12 Jerome Way, Shipton On Cherwell, Kidlington,
OX5 1JT

23/00777/F

Proposal: Single storey side extension, front porch extension, part two storey and part single storey rear extension together with associated internal and fenestration alterations

Drawing Title: PROPOSED ELEVATIONS

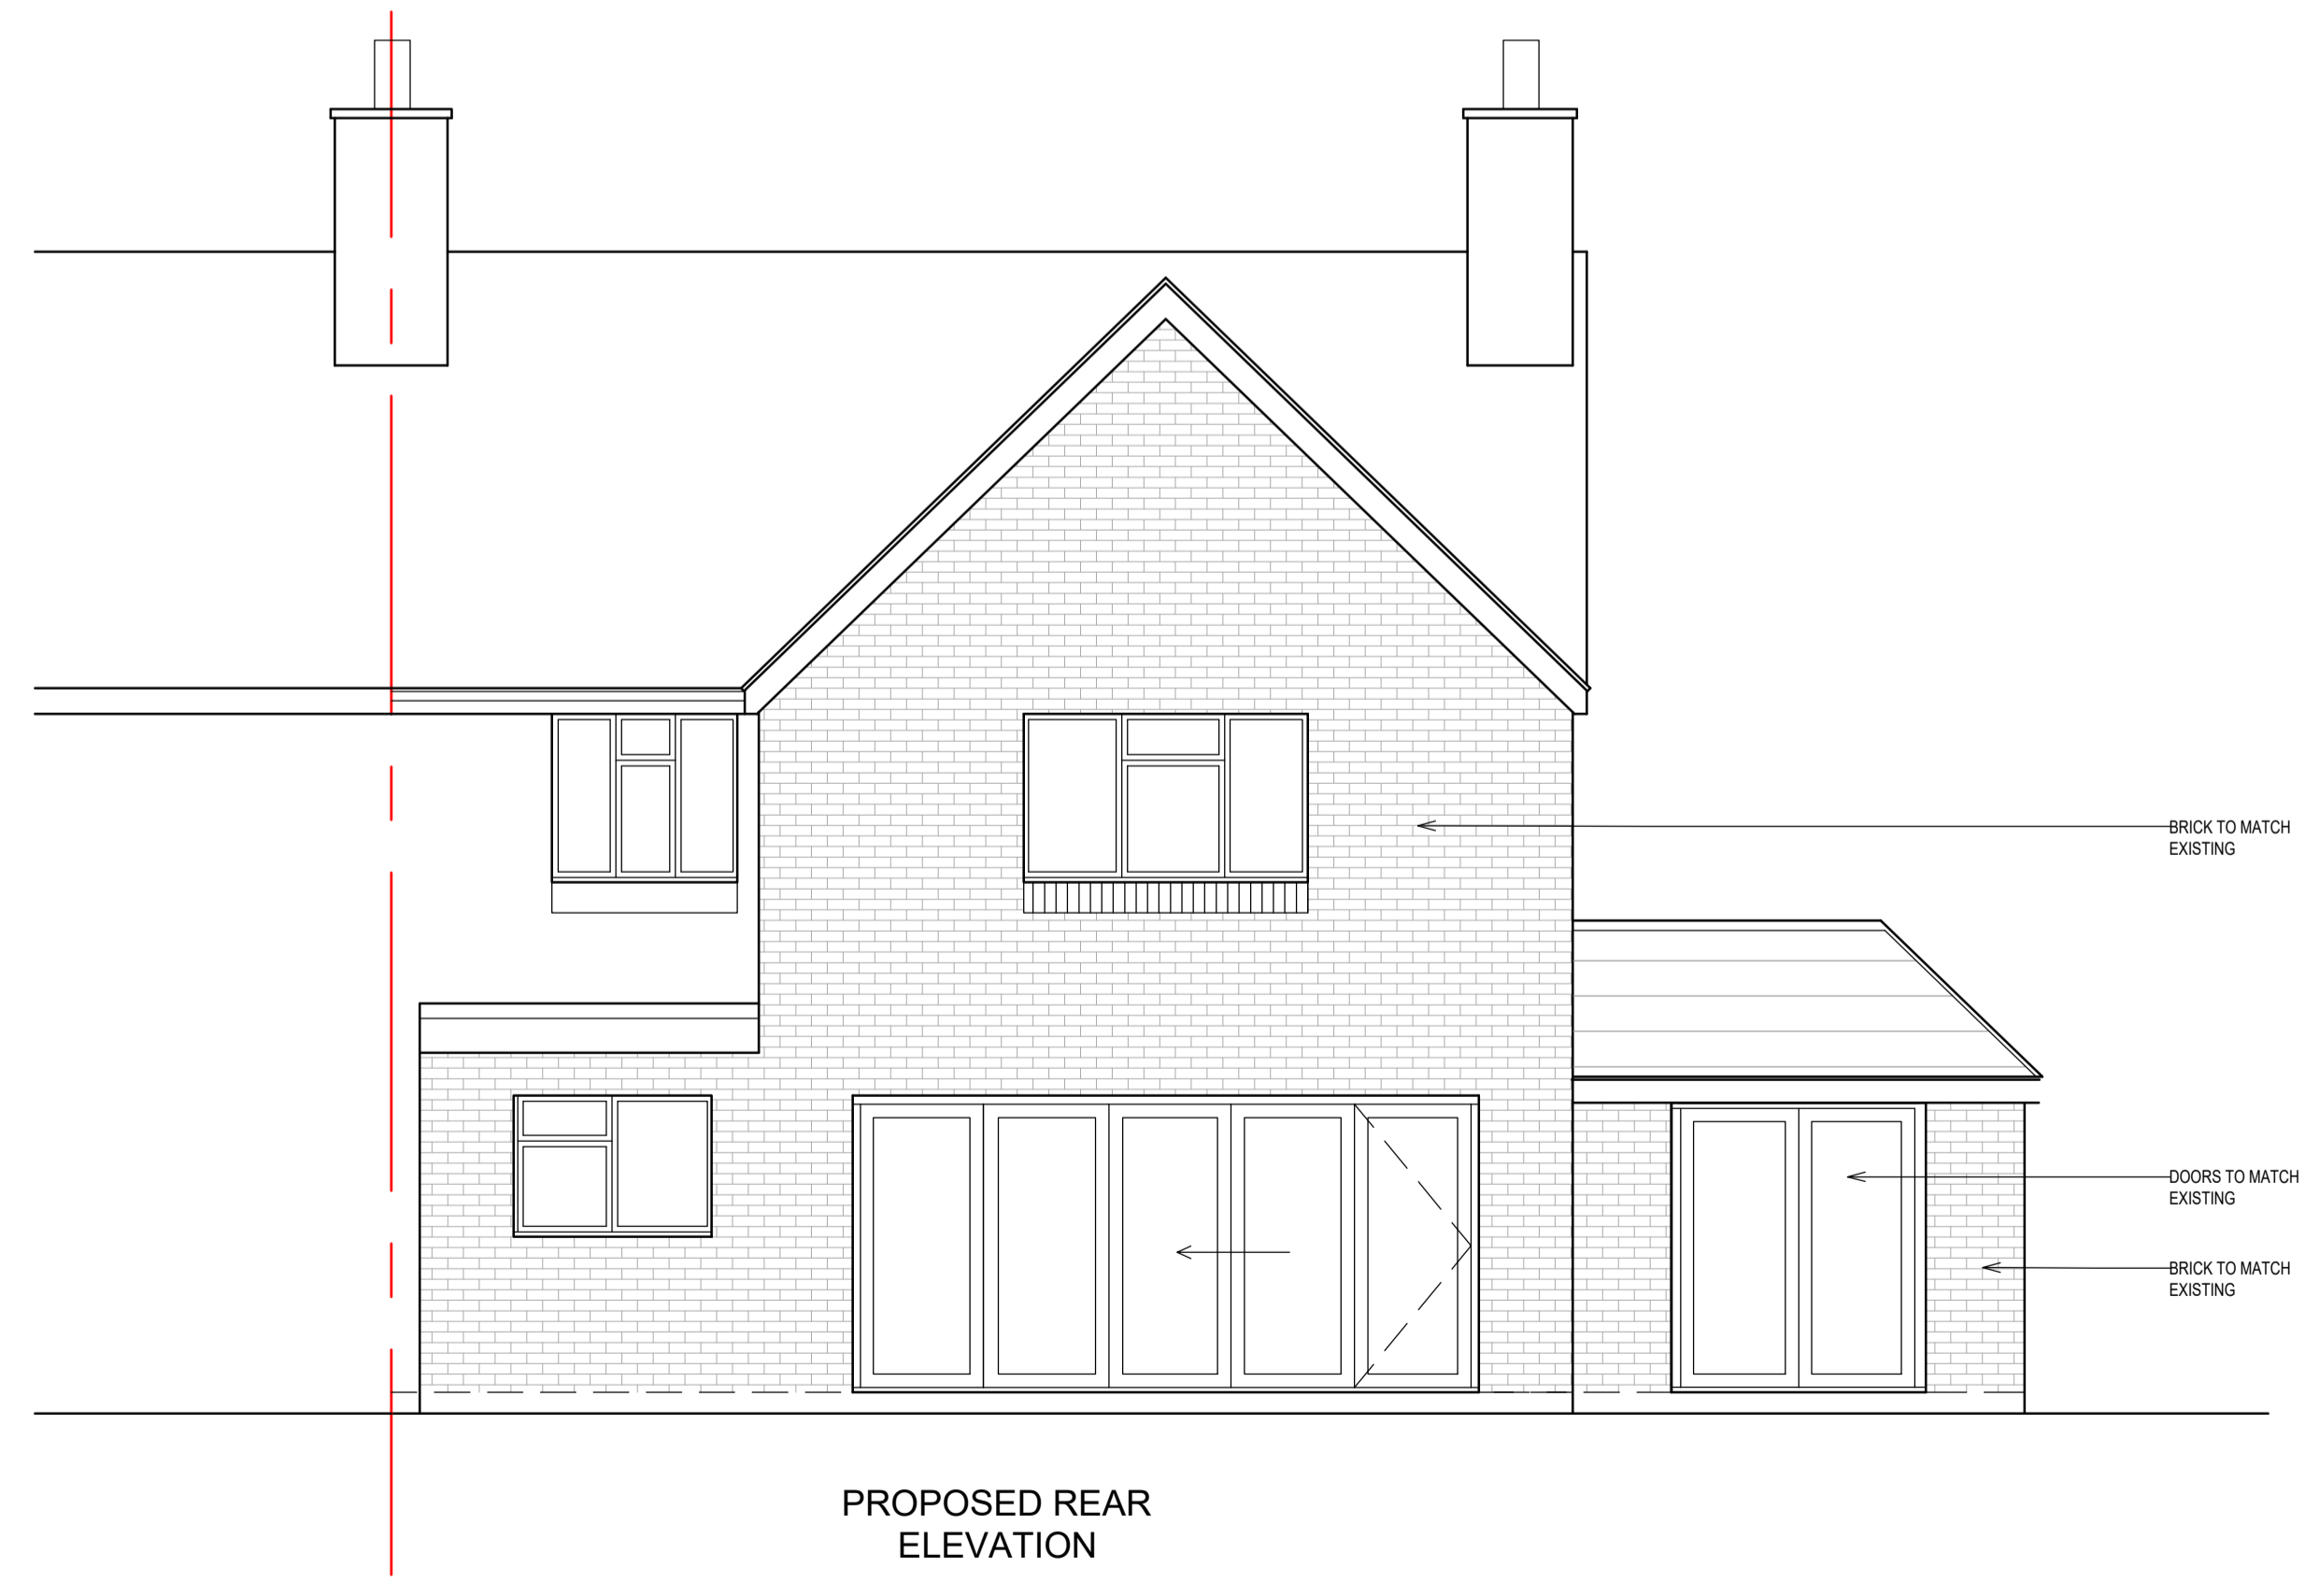
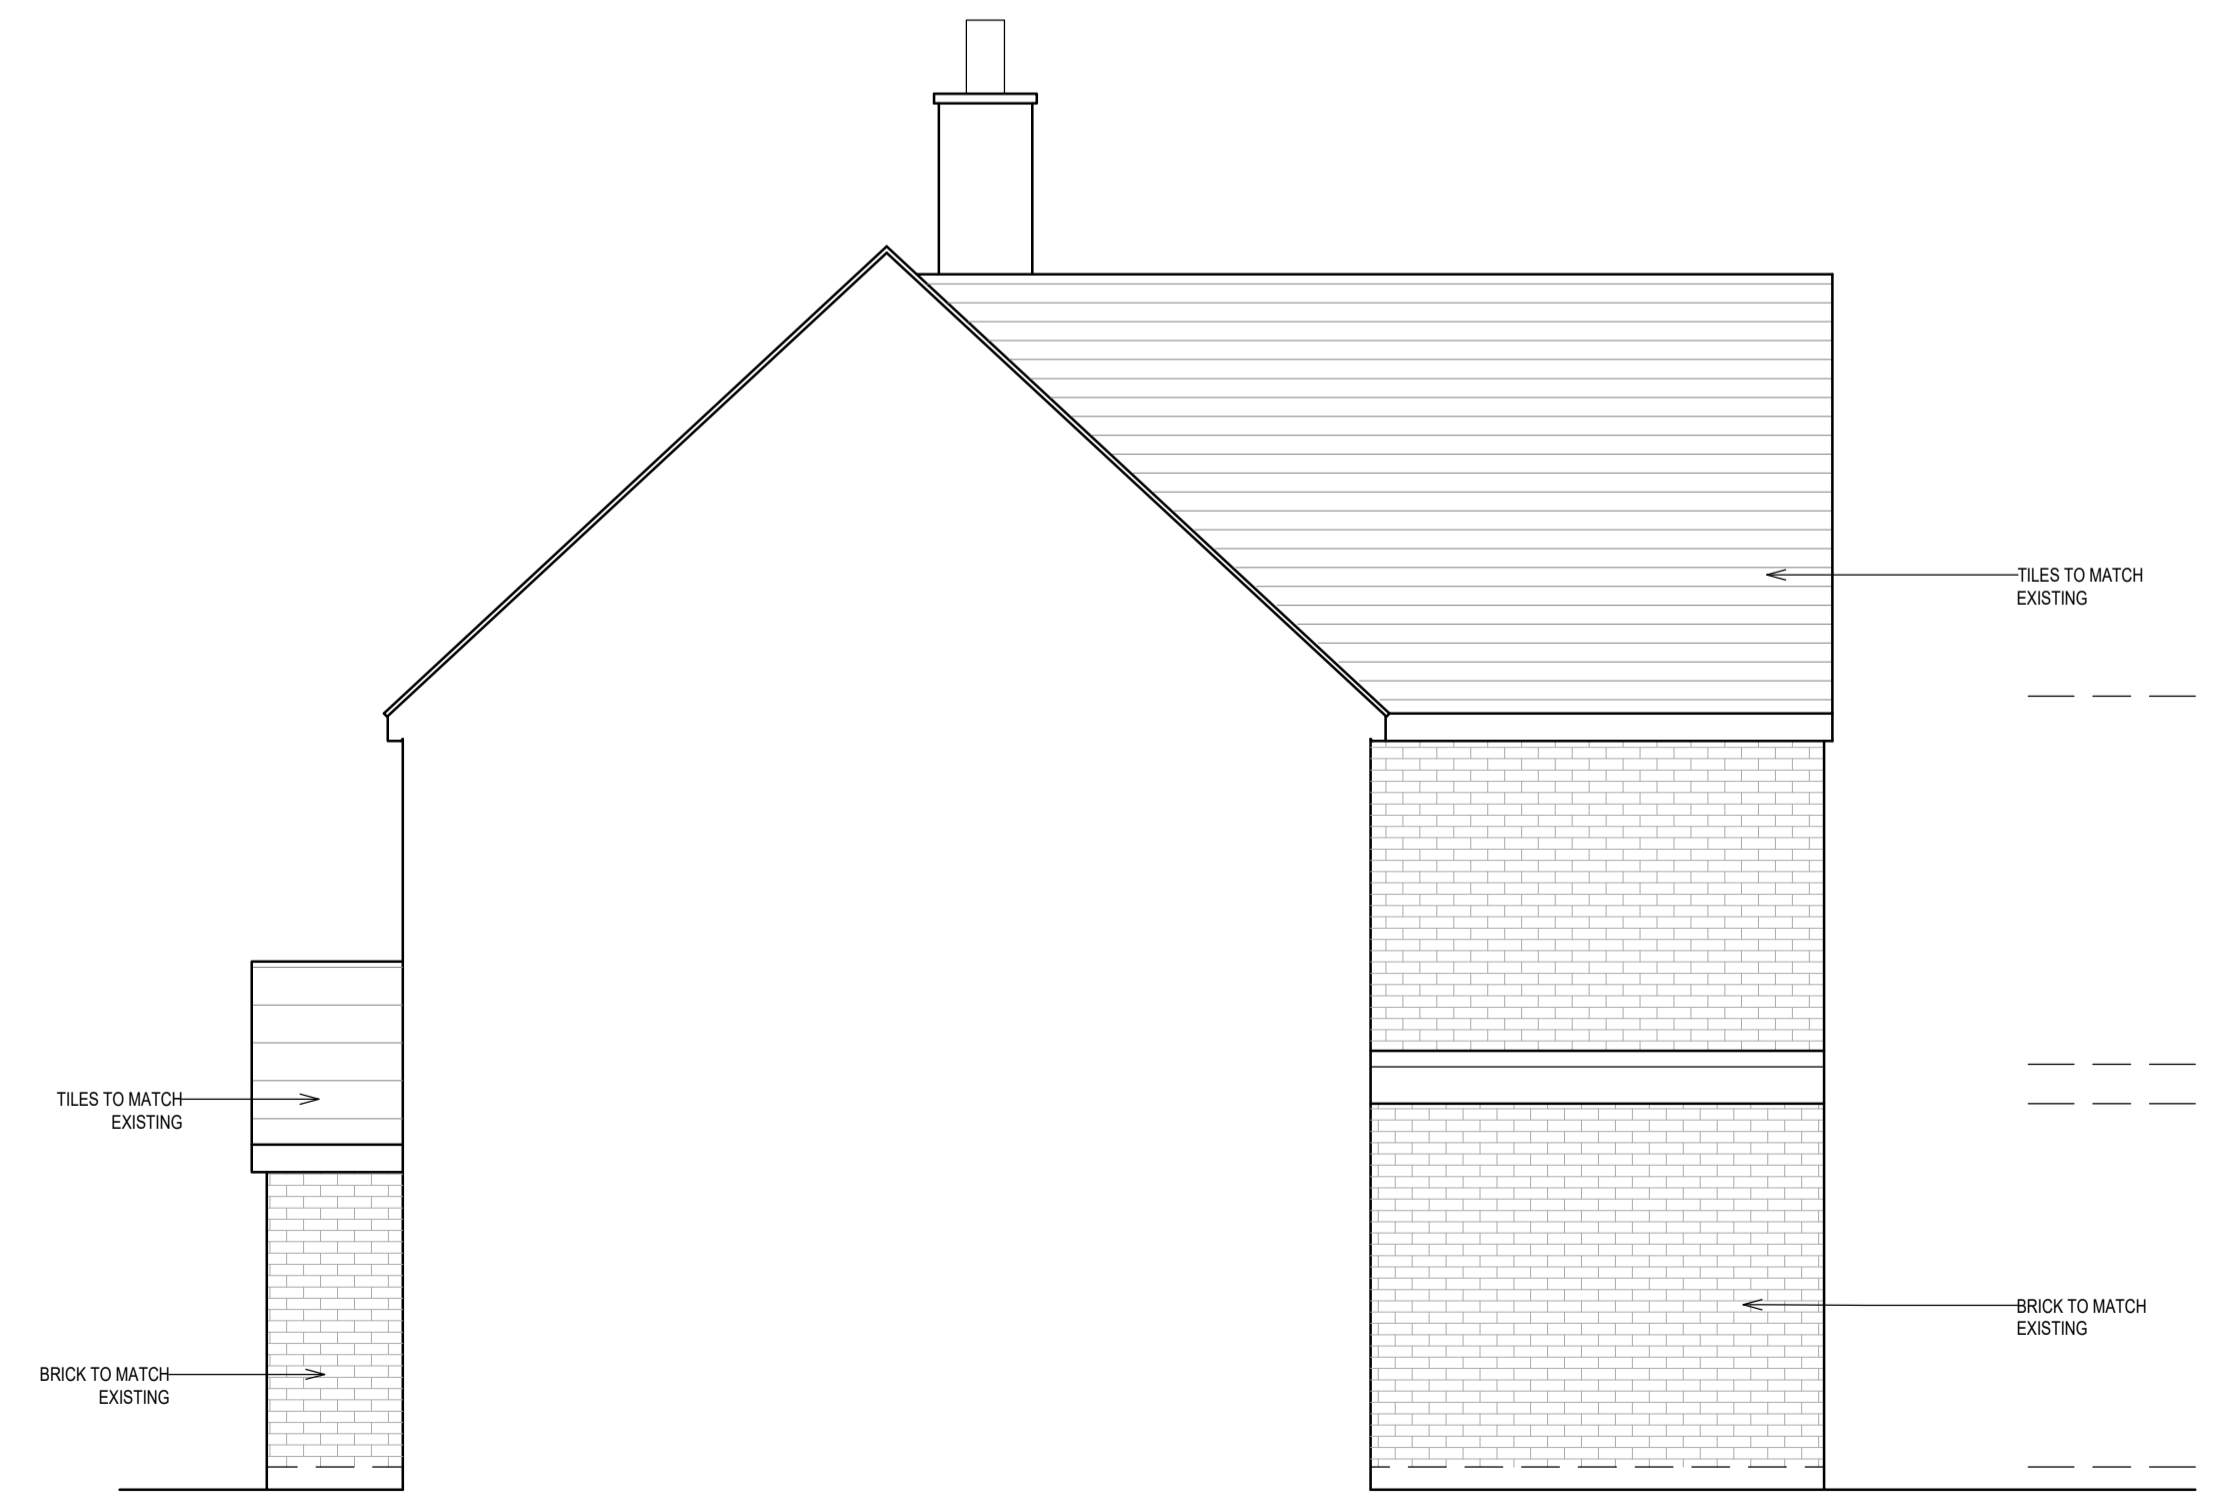
The proposal includes a single storey side extension which would be readily visible from the public realm, the plans also the proposal would be set down from the existing ridge line and set back from the principal elevation this shows subservience between the original ridge line and the proposed extension and would adhere to the

guidance within the Cherwell District Council Home Extensions and Alterations Design Guide (2007). The proposed side extension depth is considered modest and proportionate to the existing dwelling. This ensures the extension is subservient to the dwelling and the original house remains the dominant element of the property. Therefore, the side extension would have minimal impact on the character of the area.

The proposed front porch extension would be approx. 2m² with a gable roof where the ridge height would be close to the first-floor windows. Guidance is set out within chapter 5 of the Home Extensions & Alterations Design Guide March 2007 which advises that front extensions should normally be limited to appropriately sized porches and that porches should reflect the character, proportion, and scale of the existing building. Front porches in the area are characterised by a variation of different styles normally modestly sized. The porch size has been reduced from the original application. Although the comments of the Parish Council are noted, the revised porch design is a proportionate size and is considered to be of an acceptable design.

The proposal will include four windows and one door on the side elevation. This includes one door and one window on the ground floor, leaving three windows on the side elevation of the first floor. The window on the rear extension would serve an en-suite bathroom, with the two windows on the existing dwelling serving a bedroom and bathroom respectively. All three windows on the first floor are shown on the submitted plans to be of obscured glazed and non-opening. This will be conditioned to protect the neighbouring residents' amenities.

3. The three windows on the first floor of the side elevation shall be obscure glazed, using manufactured obscure glass that is impenetrable to sight, (not an applied adhesive film) before the extension is first occupied and shall be permanently retained as such thereafter. The window shall also be non-opening, unless those parts which can be opened are more than 1.7m above the floor of the room in which it is installed and shall be permanently retained as such thereafter.
